**WELWYN HATFIELD BOROUGH COUNCIL
EXECUTIVE DIRECTOR - PLANNING, PUBLIC PROTECTION AND GOVERNANCE**

DELEGATED APPLICATION

Application No: 6/2018/0291/HOUSE
Location: 44 The Ridgeway Cuffley Potters Bar EN6 4BA
Proposal: Erection of a double storey side and single storey rear extension, front porch with access, driveway and frontage alterations
Officer: Mr William Myers

Recommendation: Refused

Rev:	Details:	Date:
Project:	Drawn By:	
44 The Ridgeway	SOM	
Cuffley	Date Drawn:	
EN6 4BA	19/01/2017	
Drawing Title:	Drawing Number:	
PROPOSED SECTION A-A	TDC027/PL/303	
STREET VIEW A1	Scale:	Rev:
	1:50	-

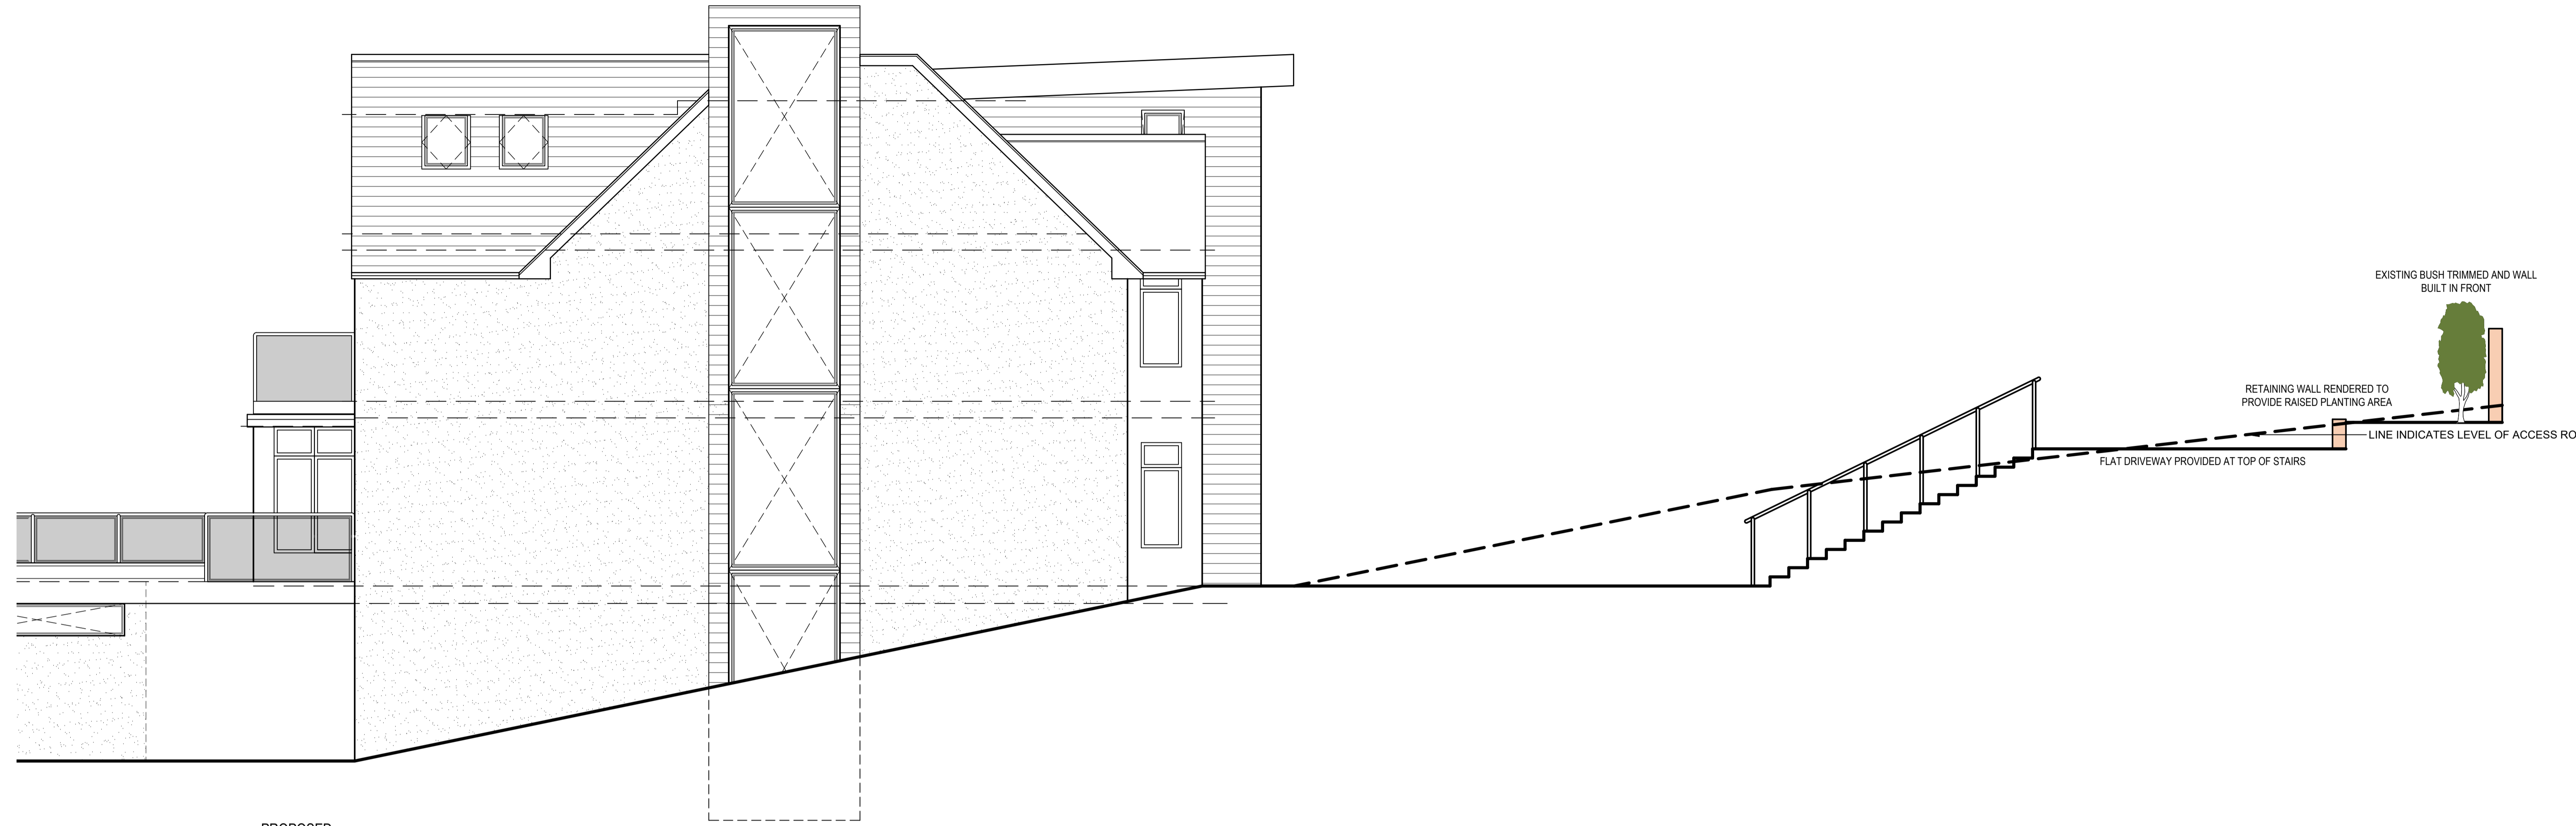
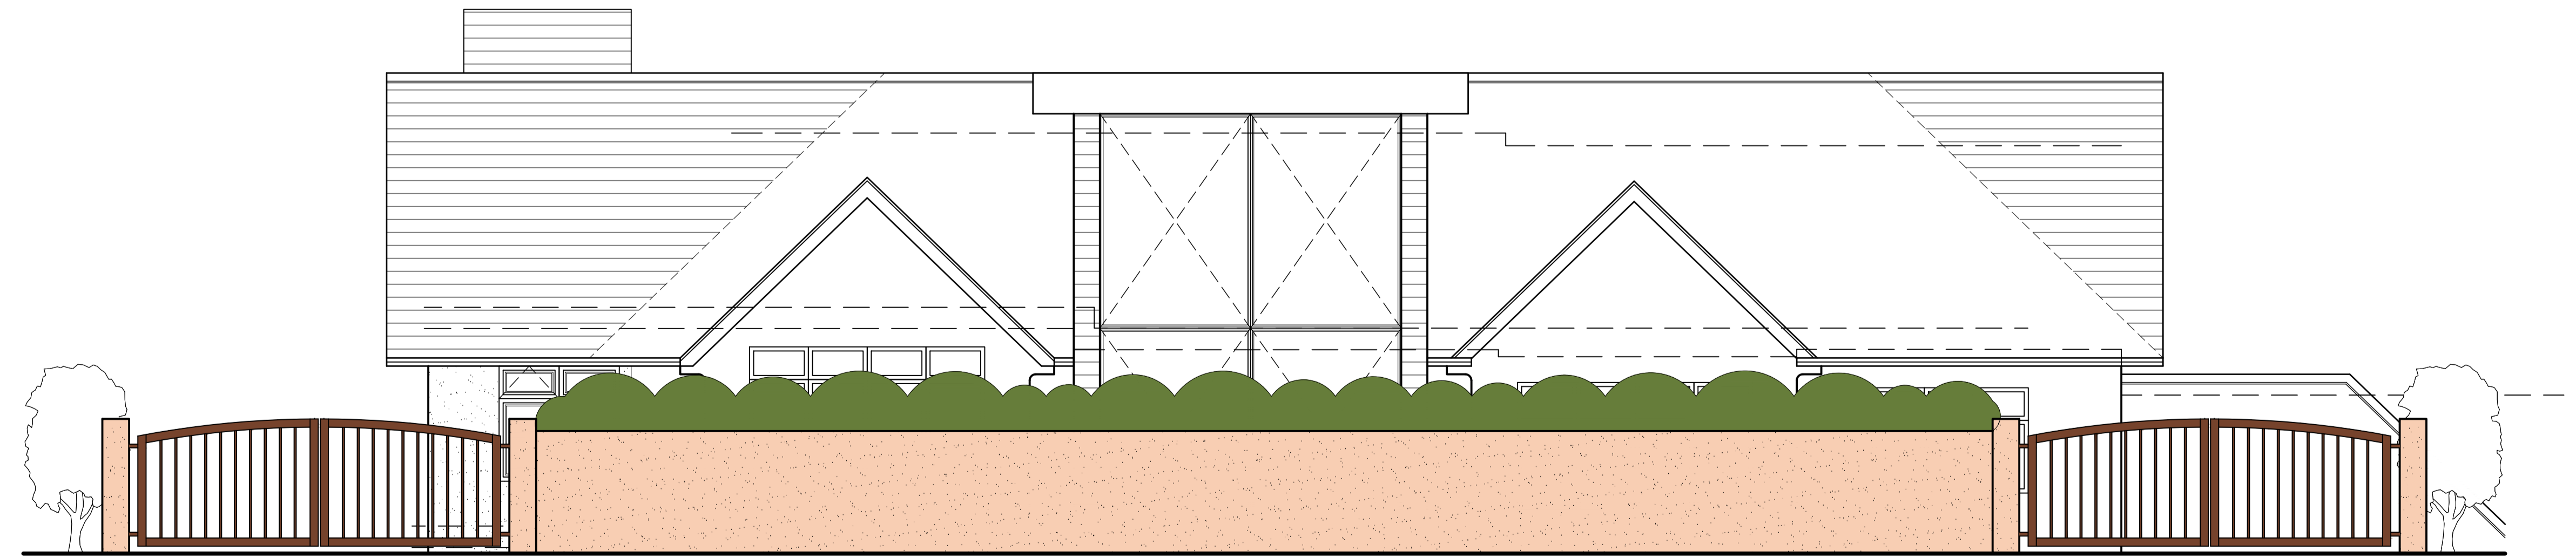
- A two storey side extension, a single storey rear extension;
- the creation of a two storey porch to the front of the property which would have a flat roof which would be effectively equal in height to the ridge line of the existing dwelling;
- the changing of the current hipped roofs on both side elevations of the dwelling to gable ends;
- The increasing of the roof height on the existing larger rear projection so that it is level with the ridge line of the main roof and no longer set down by approximate 0.4m; and
- The increasing of the width of the existing larger rear projection by approximately 2.5m.

<p>Further to the above discussions about the proposed increases, it is considered that such substantial additions to a dwelling, which has already been significantly extended, would have a harmful impact on the openness of Green Belt. The design, character and appearance of the proposed extensions would not be consistent with the general pattern of development and character of the area. The essential characteristics of Green Belts are their openness and their permanence and the loss of openness in the Green Belt resulting from the proposed extensions would conflict with this essential characteristic. Significant weight must be attached to this loss of openness.</p> <p>The proposal would add further development to an already disproportionately extended dwelling. For the reasons discussed, the proposal fails to meet the exceptions set out in paragraph 89 of the NPPF. It would, therefore, be inappropriate development in, and thus harmful to, the Green Belt. It would also conflict, with Local Plan Policy RA3 and emerging Policy SADM 34, which seek, among other things, to ensure that extensions, either alone or cumulatively with other extensions, do not result in disproportionate additions over and above the size of the original dwelling. Furthermore, the increased bulk and massing of the proposed development would result in a loss of openness and visual permeability of the Green Belt.</p>
